RE: SUB19-002/SEP19-005 – Proposed Preliminary Plat
2825 W. Mercer Way, APN 2174502425
Request for Additional Information, Third Review
Blueline Job No. 13-118

This letter is in response to your review of the SUB19-002/SEP19-005 project. The plans have been revised per the comments in your letter dated 1/09/23. Below is a list of each comment with our responses in bold.

2/16/23
 JOB NUMBER: **13-118**
 SHEET NAME: **GP-01**
 SHT **4** OF **9**

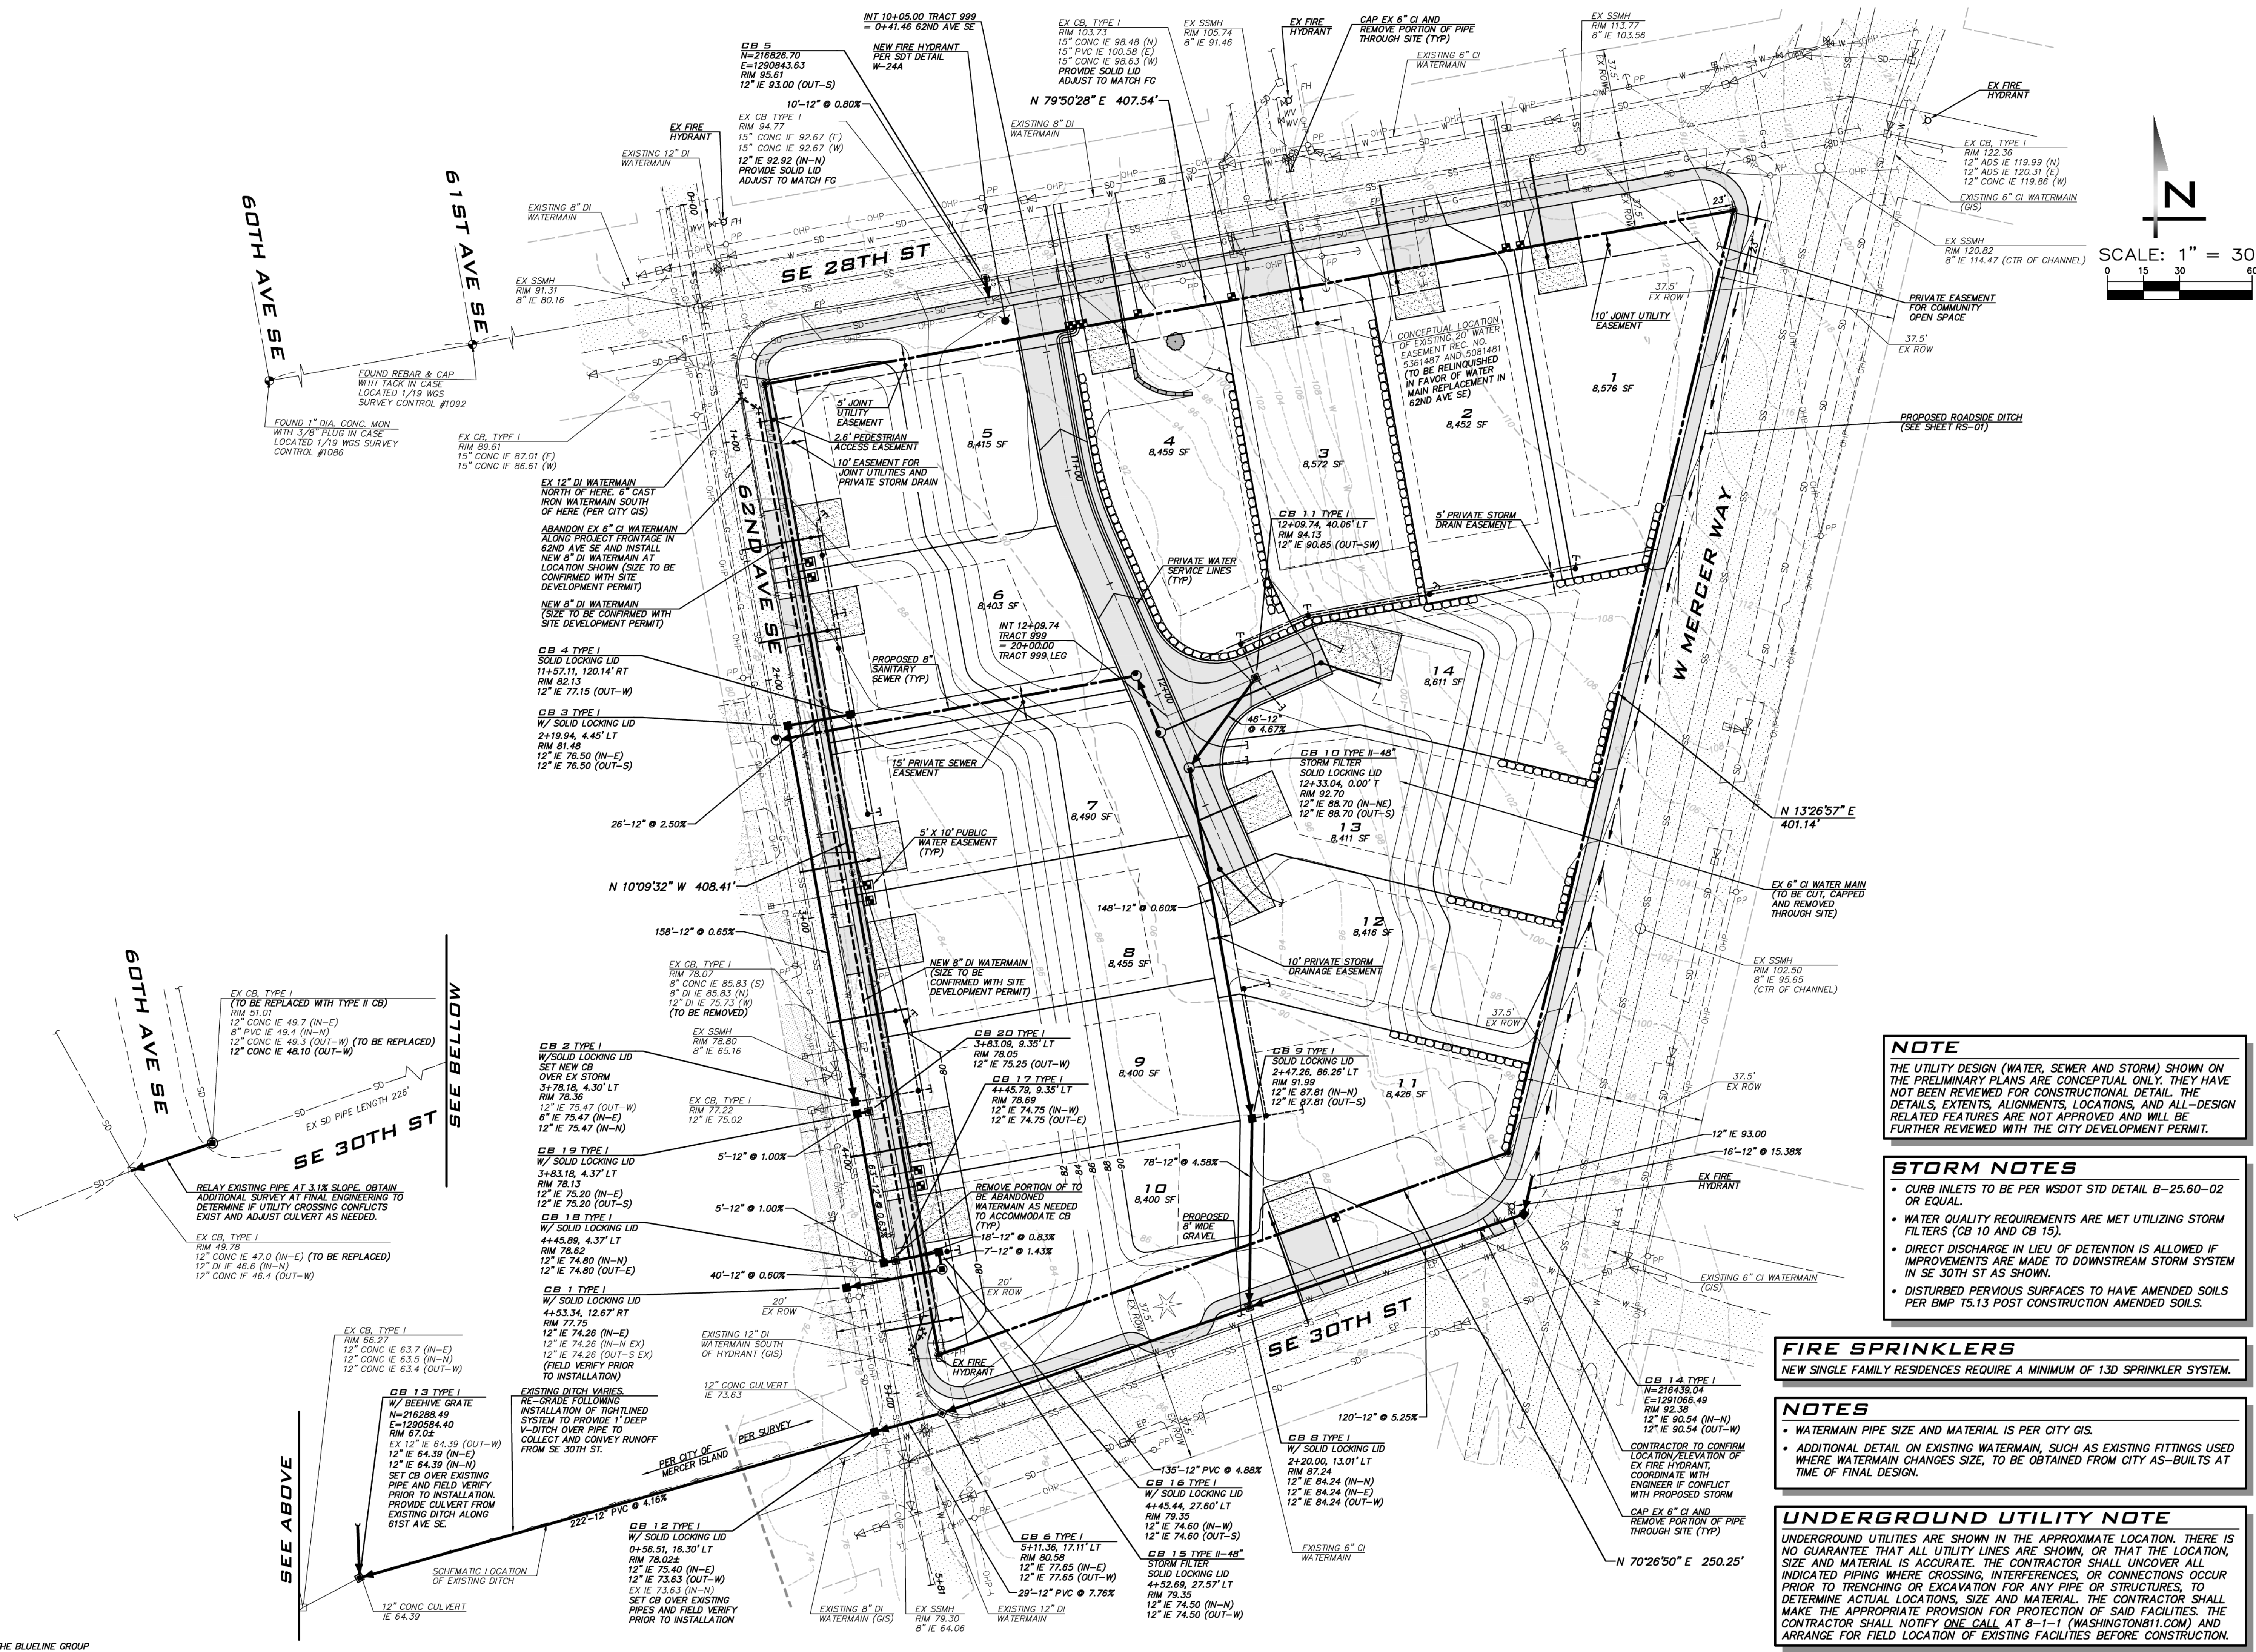
1. Second repeat correction. A new wall not shown in Sub 1 looks to be within the tree protection zone. The construction of the wall as shown would encroach into the tree 2's protection zone. Place this wall with enough room to construct without encroaching into the tree protection zone. As suggested in a Planning comment a longer driveway would resolve this issue. The building pad, driveway, grading and wall to be shown outside that limit with enough space to reasonably construct building. This means showing at least 5' of space between building pad and driveway in addition to the 16' of protection. SUB3 still shows the retaining wall right against/within the tree protection. This could not be built without taking the tree protection down and encroaching into tree 2's limits of allowable disturbance. A call out states 5 feet between the tree protection and wall and building pad. But this is not clearly shown. Show building pad and wall with this clearance. Move both the building pad and the wall to keep the 16-foot tree protection zone from the face of the tree to the chain link fence.

The wall has been relocated so that it is a minimum of 1' off of the dripline/tree protection fence such that the tree protection fence can remain in place while the wall is installed. Given the height of the wall adjacent to the driveway (0'-2.5') and distance from the dripline/tree protection fence (1'-5'), the work to install the wall should fall outside of the dripline. Refer to details on sheet GP-01 showing grading in the area of tree #2. An additional callout regarding work adjacent to the dripline has been added to sheet GP-01 and TR-01. This approach was confirmed with the City on 2/16/23.

2/16/23
 JOB NUMBER:
13-118
 SHEET NAME:
UP-01
 SHT **5** OF **9**

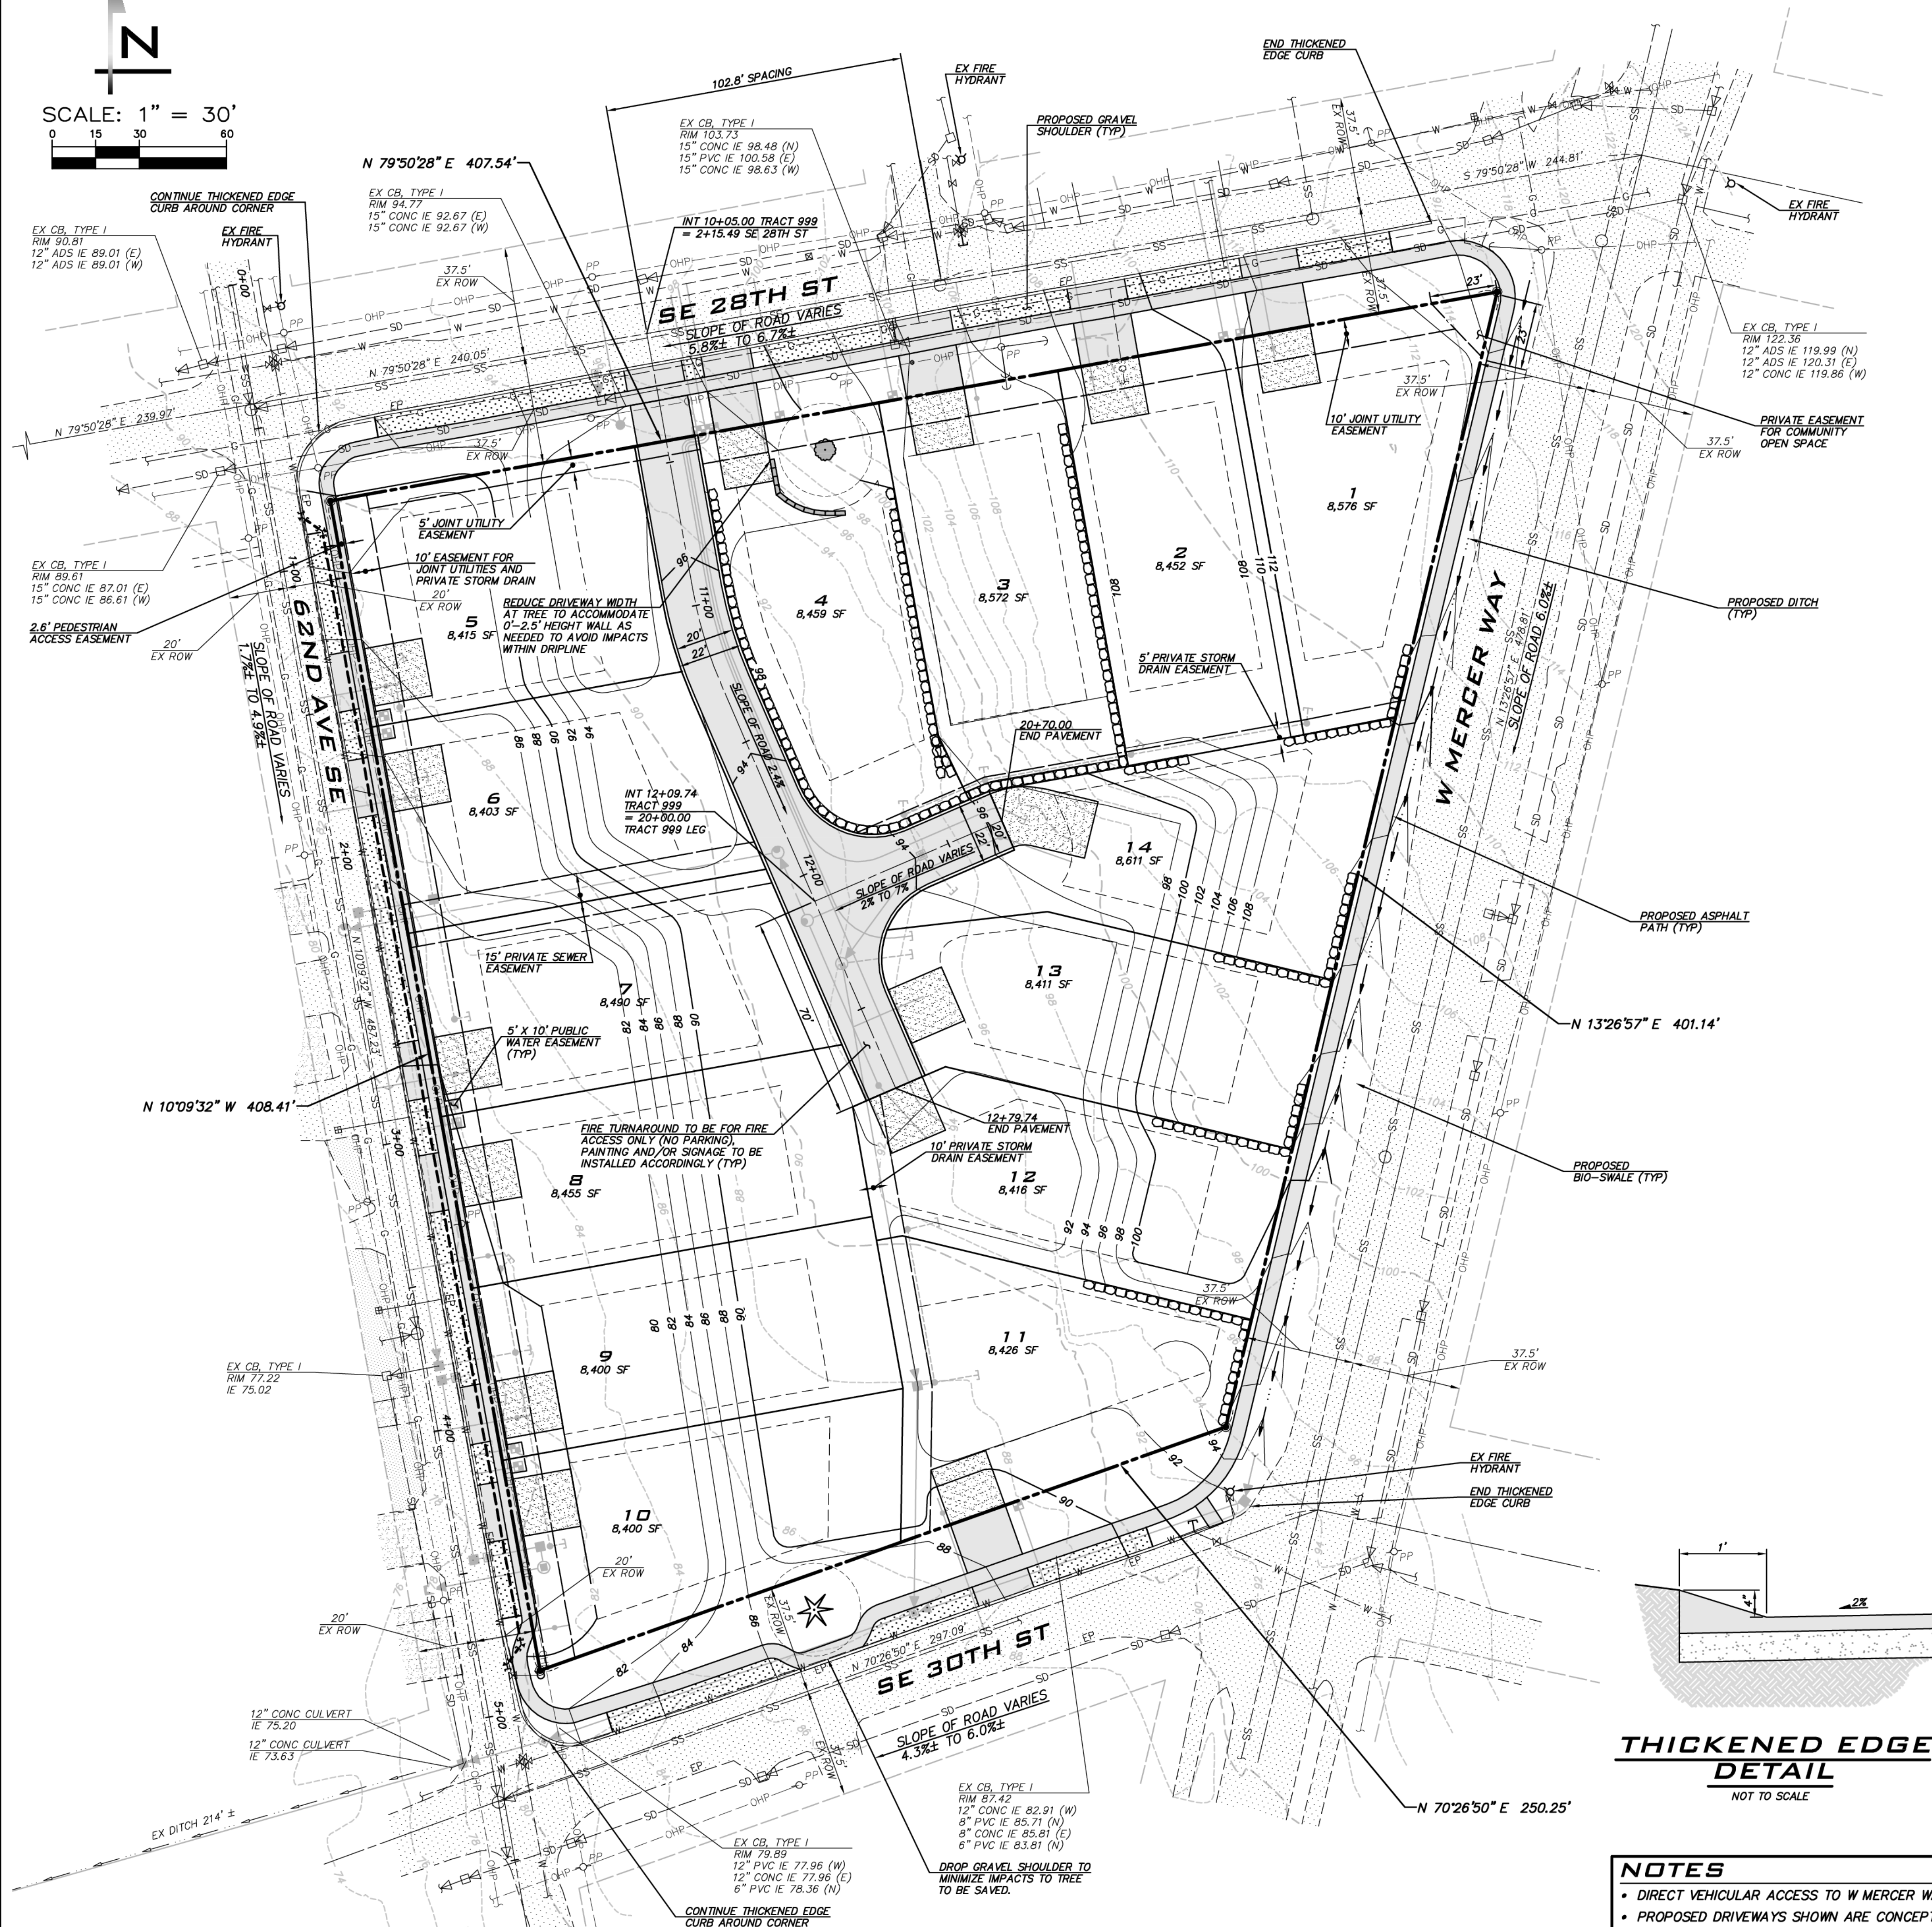
6. Storm Drainage and Utilities:
 - a. The bioretention system should not be in the City ROW.

- b. Storm drainage design at the intersection of W. Mercer Way and SE 30th Street: Providing a new 10' of 12" DI pipe running north to south and adding a new Catch Basin at the end of the new 12" DI pipe, so the pipe's mouth is in line with the proposed ditch, rather than a 45 degree as shown.

- c. The section of the existing ditch on 61st Ave. SE shall be piped and shown on the plan.

- e. The sanitary sewer system for the plat is a private system, not a public system as shown.

- f. The new water main will likely be a 12" DI and a water modeling will be required.

5. Hydrant spacing- Does not meet standards: IFC C102 Number of Hydrants and spacing required. Hydrants shall be located within 250 feet from the hydrant to the fire department access. Additionally, fire hydrants shall be located within 300 feet from the furthest point of the residence (w/o fire sprinkler system) and 600 feet (with sprinkler system). Currently Lots 12-13-14 exceed the distance from a Fire Hydrant. Provide a solution/ code alternative to how this requirement will be met.

The bioswale has been eliminated from the W Mercer Way ROW and a second StormFilter (or equivalent) is proposed at the SW corner of lot 10 (to be privately maintained). Per email correspondence with the City on 2/10/23, the concept of eliminating WQ systems from the City ROW is acceptable for the preliminary plat and the detailed design of the WQ facilities will be reviewed under the Site Development Permit.

The storm layout has been revised accordingly.

A culvert to collect the existing ditch along 61st Ave SE has been added.

Callouts for the sewer easement have been updated accordingly.

Callouts for the proposed water main on sheet UP-01 have been revised to include notes for size to be confirmed with the Site Development Permit.

A fire hydrant has been added at the SE 28th St/private access road intersection to meet the hydrant spacing standard. This spacing was confirmed with the City on 1/11/23.
